Conservation and Urban Design Advice

Reference: 3/21/0013/LBC & 3/21/0012/FUL

Site address: Beauchamps Cottage Wyddial Buntingford Hertfordshire SG9 0EP

This application relates to the demolition of a curtilage listed dwelling and construction of new dwelling with basement.

Drawing Title:  
**Proposed Plans, Elevations  
and Sections**

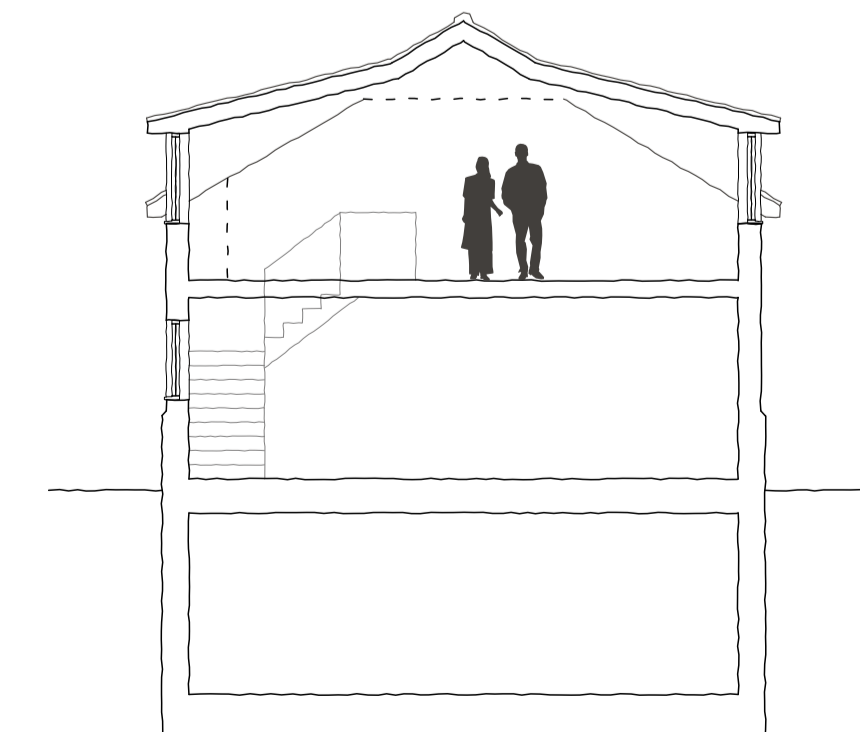
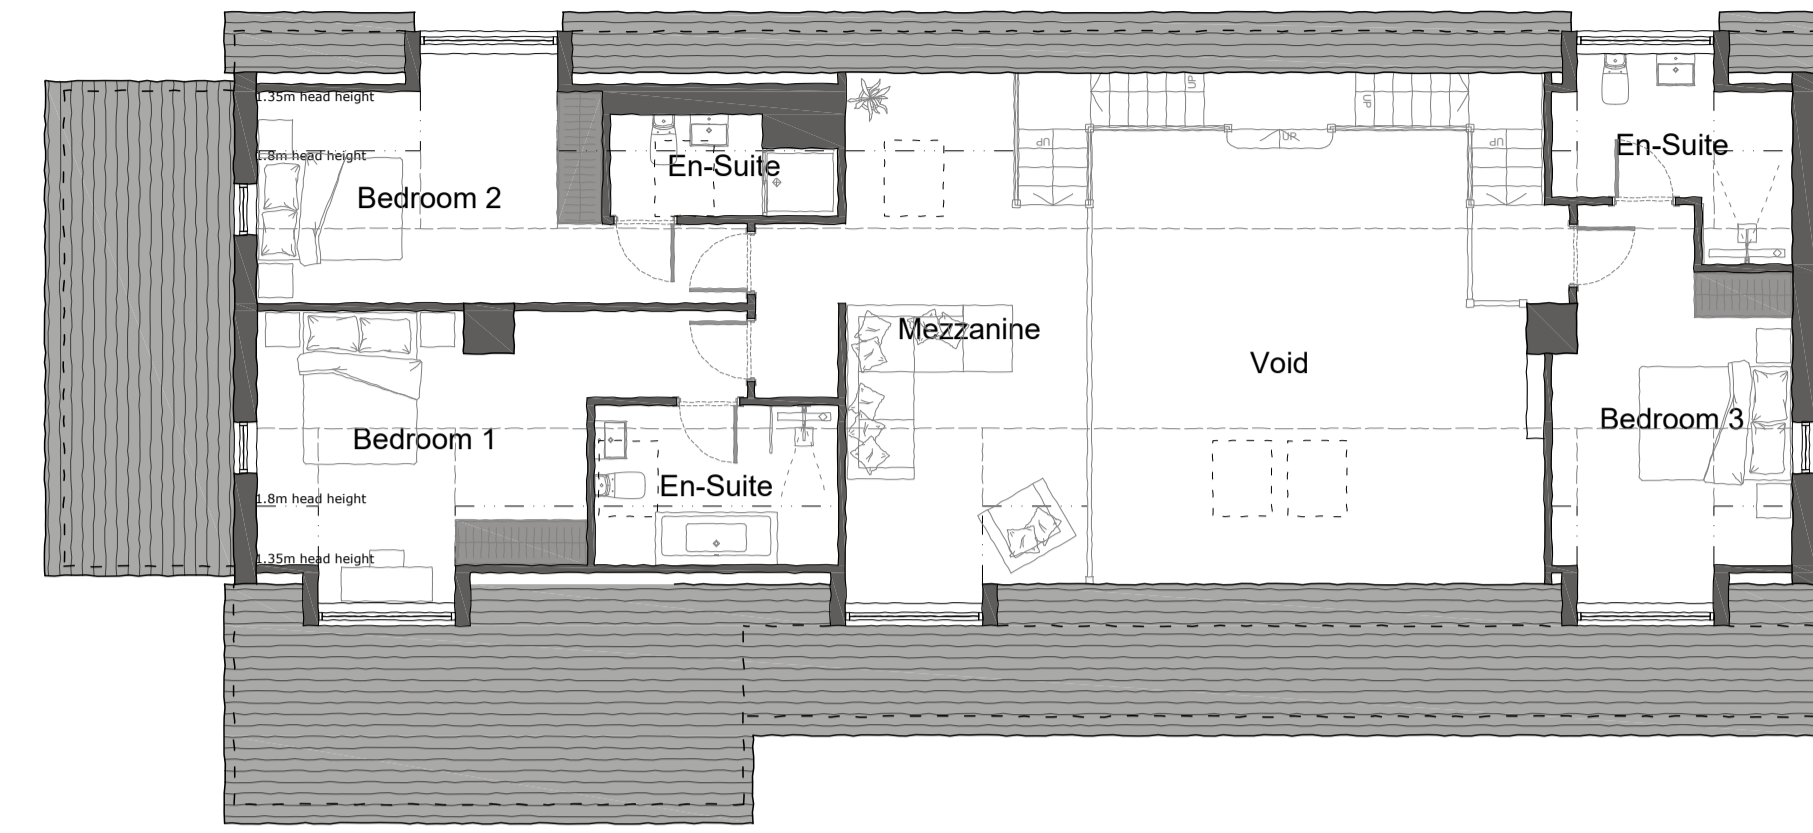
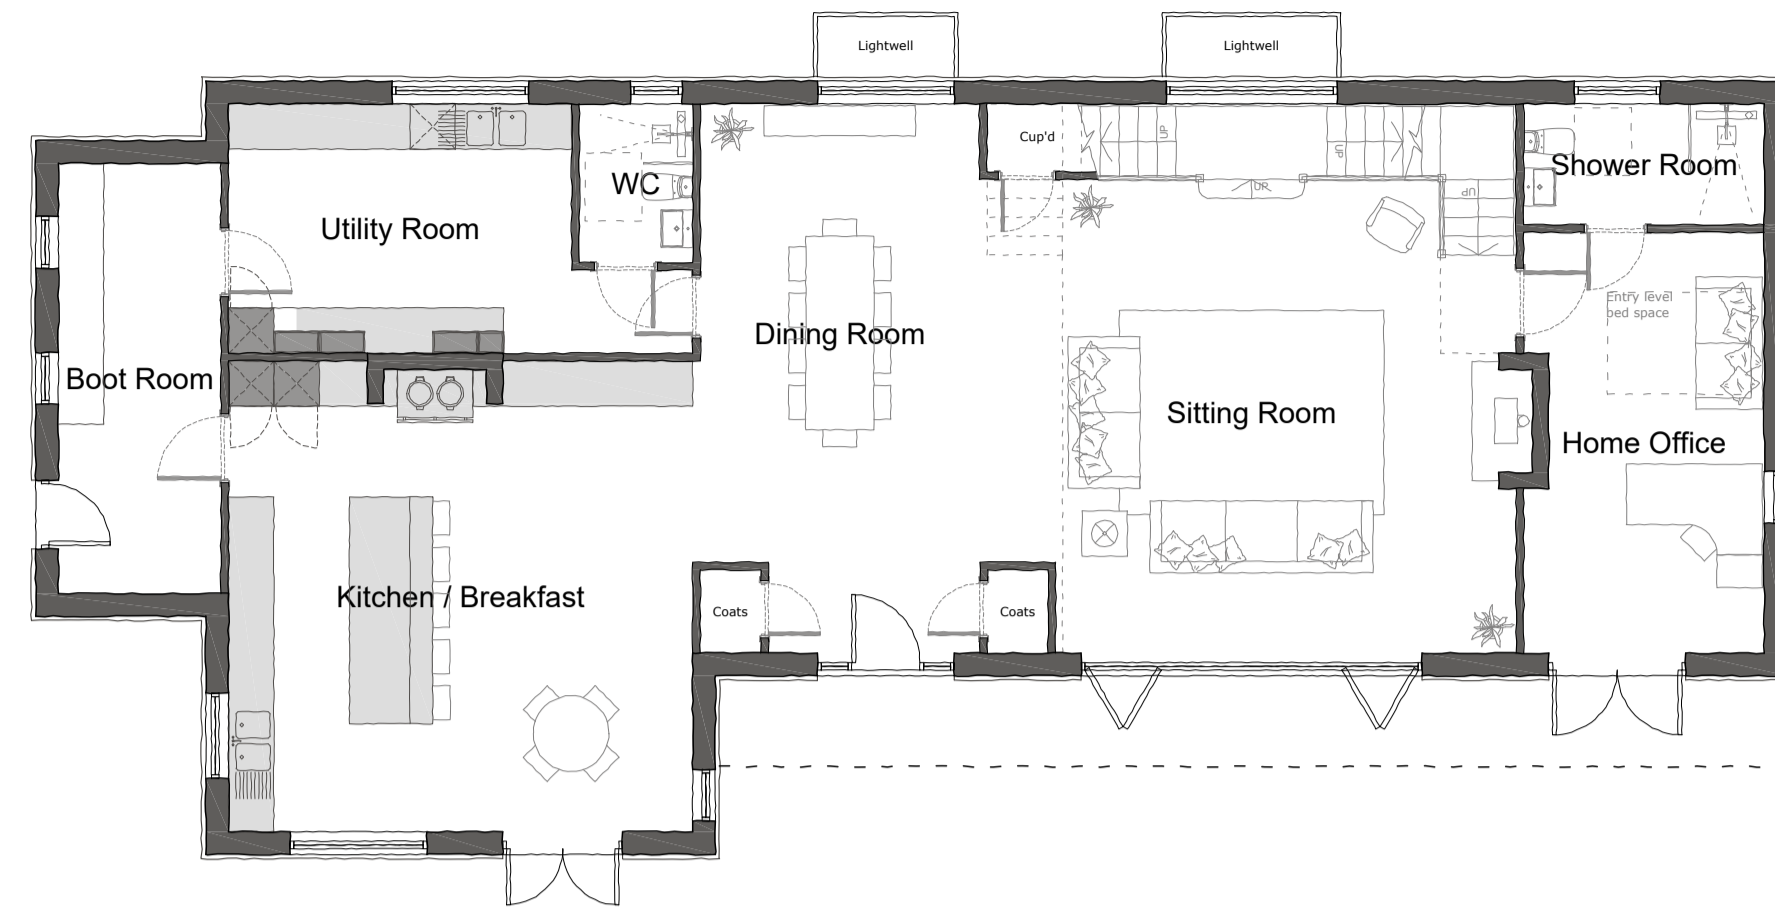
Unfortunately, the design of the building itself does not sufficiently reflect the agricultural vernacular of the existing building, which we consider an important element of any new building on this site. In particular the rear and north facades should be greatly simplified in terms of fenestration in order to present a more

agricultural appearance towards the listed building. We also do not welcome the dormer windows to both roof planes which do not contribute positively to what should replicate the simple barn shape of the existing building. Dormers could be acceptable on the proposed front elevation, but those on the rear should be omitted.

The brick plinth is too high for a traditional agricultural building and should be reduced in height.

We can see that two chimneys are indicated on the new dwelling. The one that is in the position of the original chimney appears to serve no purpose. It is the chimney at the other end that appears to be functioning. We support the effort to retain a chimney in the original location, but the internal arrangement of the dwelling itself should be reflective of the external features. The original chimney should be in use, with the original bricks reclaimed and the existing form rebuilt. The second chimney should be omitted in order to preserve the agricultural roof line at the opposing end of the building. This will require internal re-organisation of the living spaces.
